KITTITAS COUNTY COMMUNITY DEVELOPMENT SERVICES

August 23, 2019

RE: SP-19-00002 Rampart Row

RAMPART ROW SHORT PLAT APPLICATION

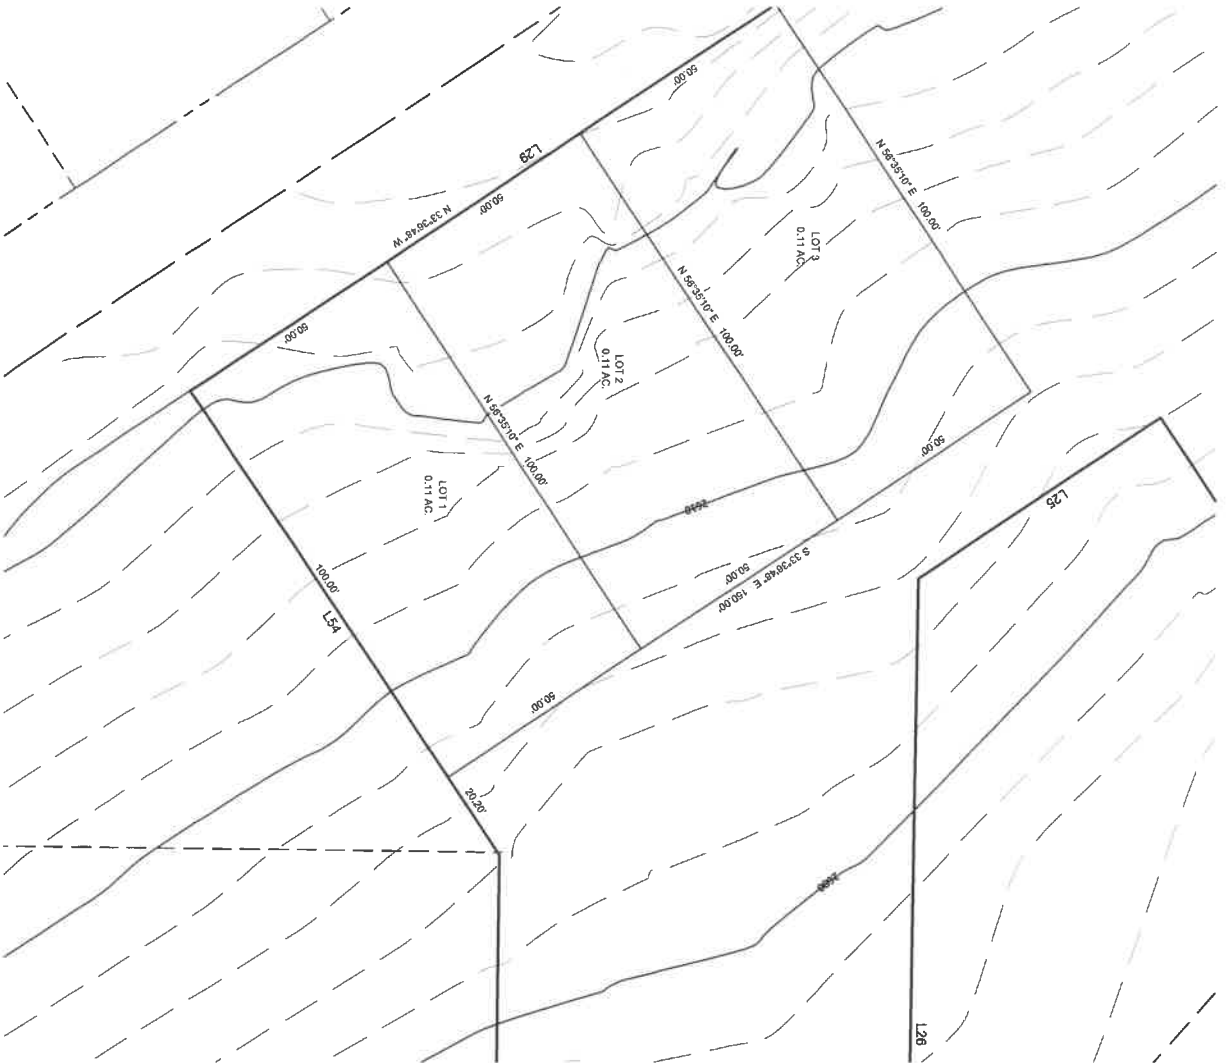
1. Consideration should be given for the setbacks from propane tanks to buildings and property lines per the International Fuel Gas Code and the NFPA 58 current adopted versions at the time of permit submittals.
